# CITY OF ALBUQUERQUE

June 8, 2018

RE: **Penske Truck Leasing Addition (BP-2017-35106)**  
**1400 Candelaria Rd NE**  
**60 Day Temporary C.O. - Accepted**  
**Engineer's Stamp Date: 10/20/17**  
**Certification Dated: 6/5/18**  
**Hydrology File: H15D052**

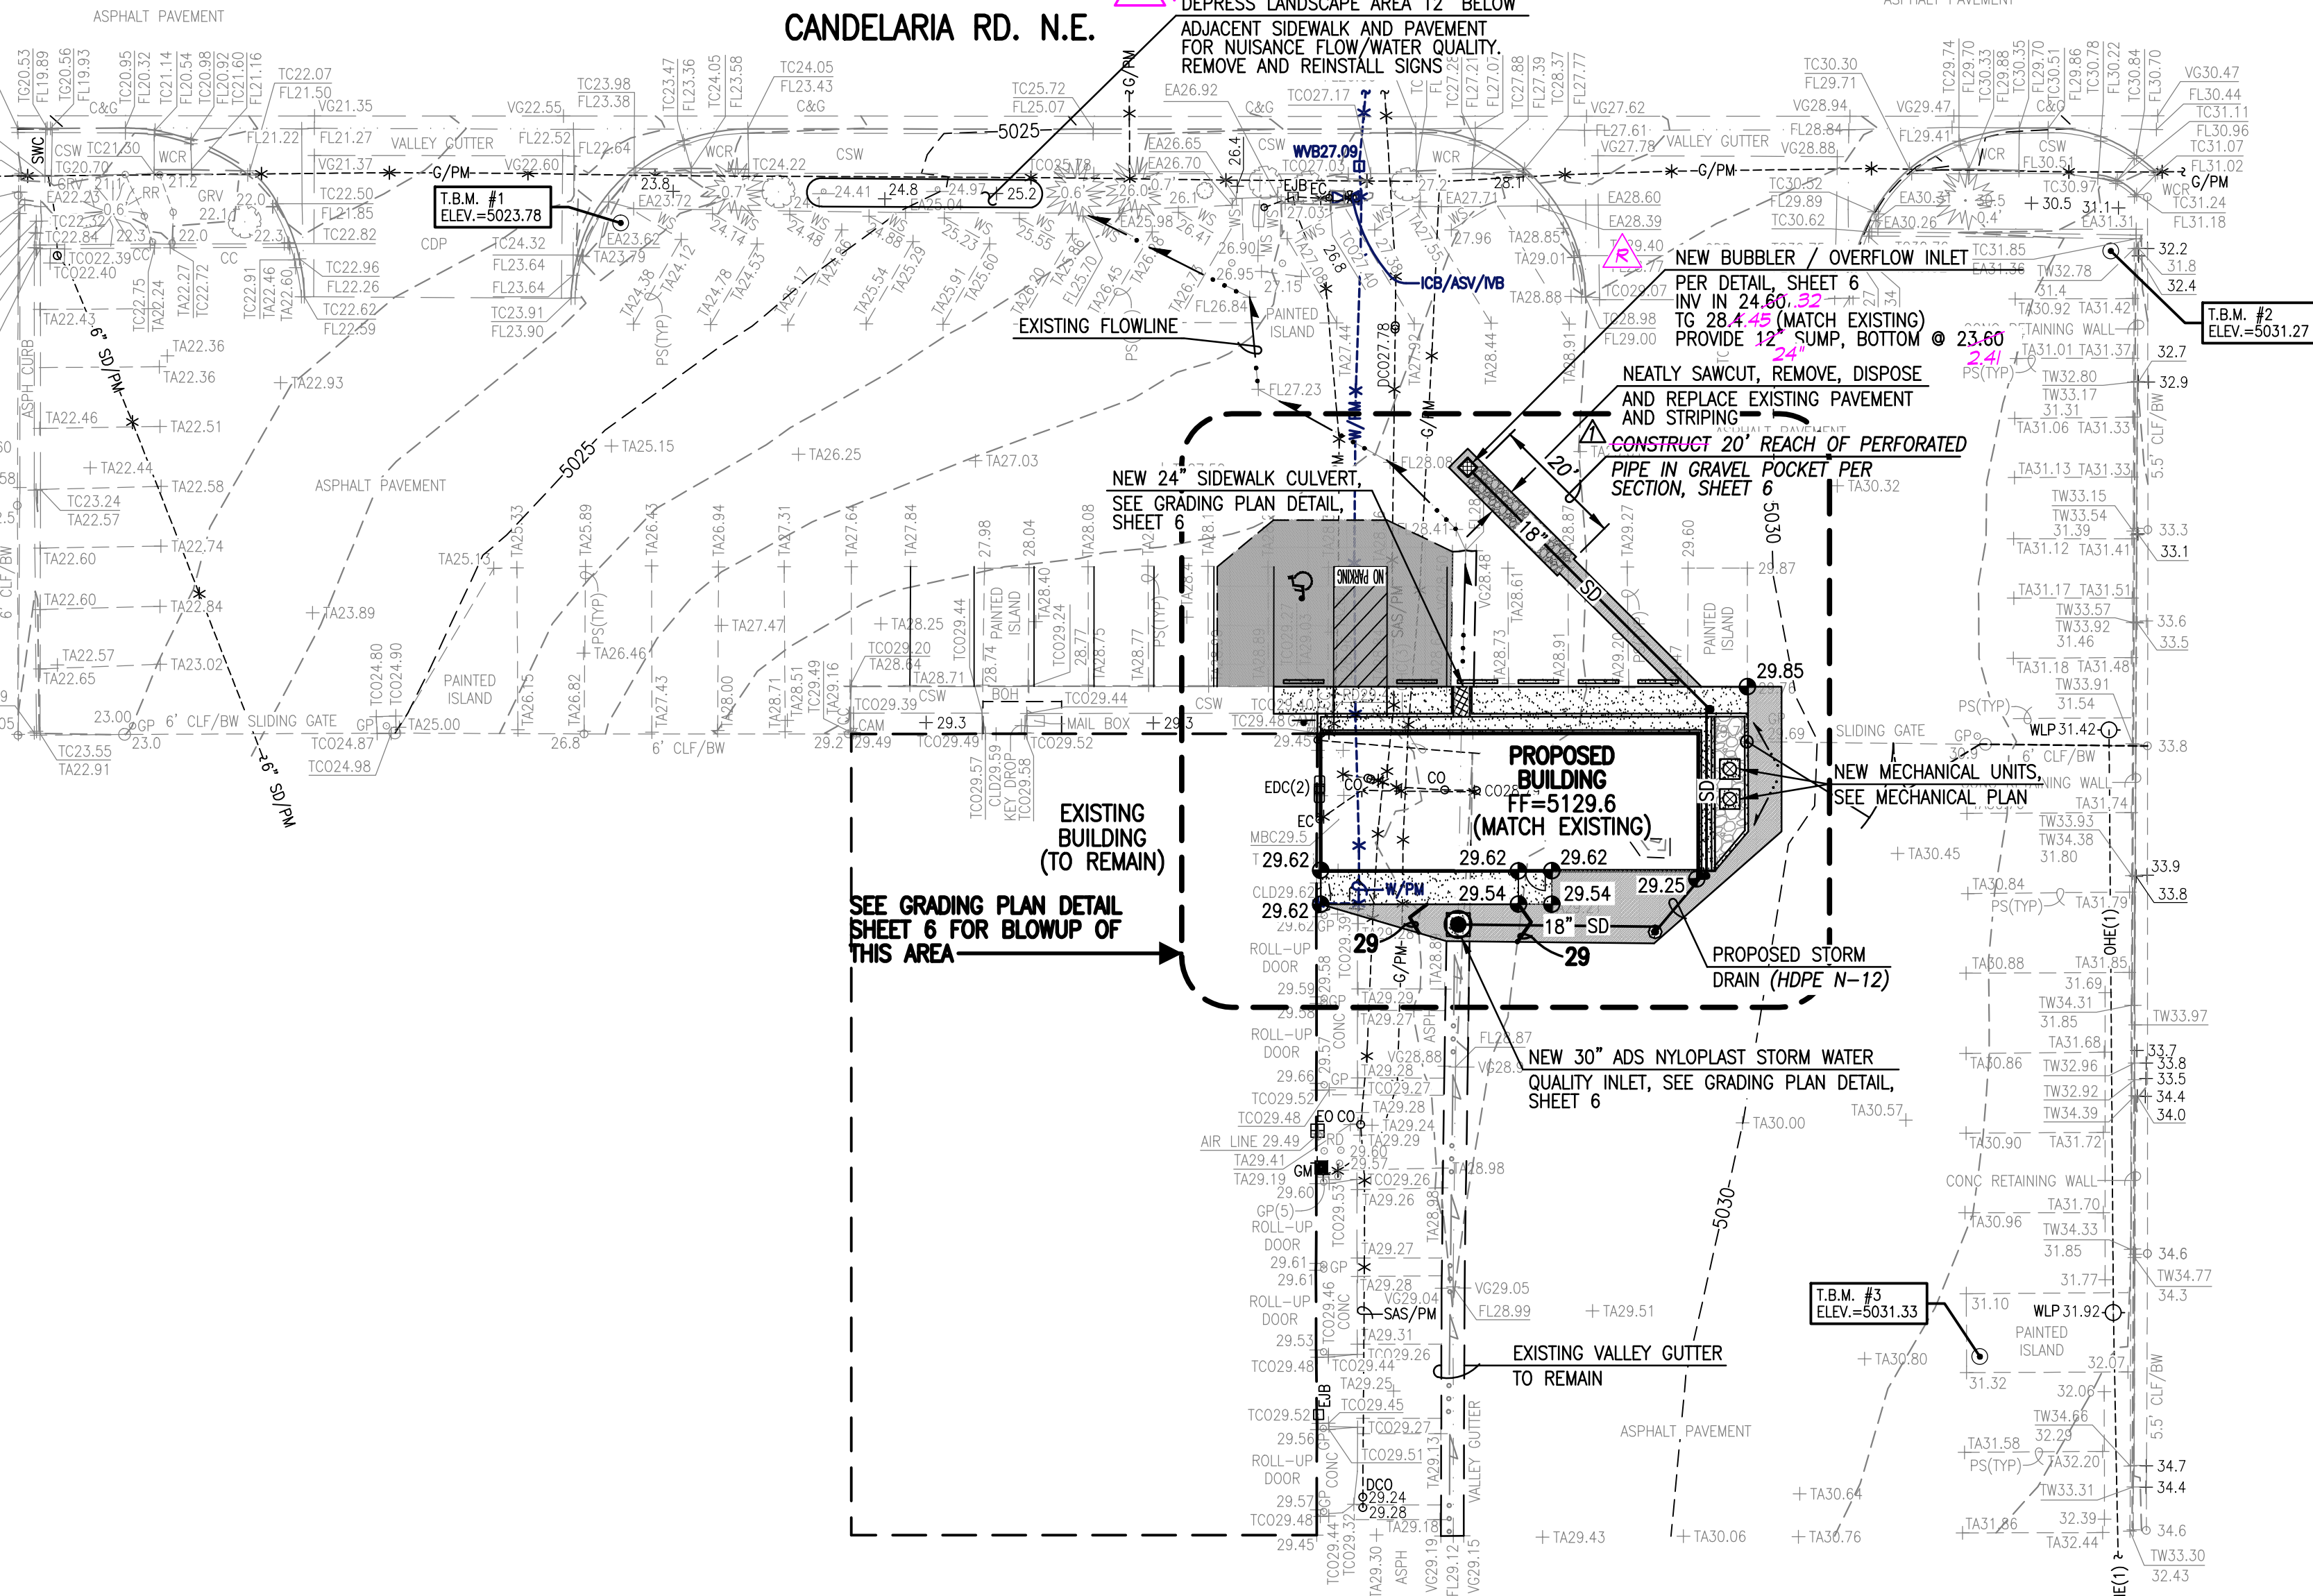
1. The landscape area located at the north edge needs to be depressed 12" below the adjacent sidewalk and pavement.
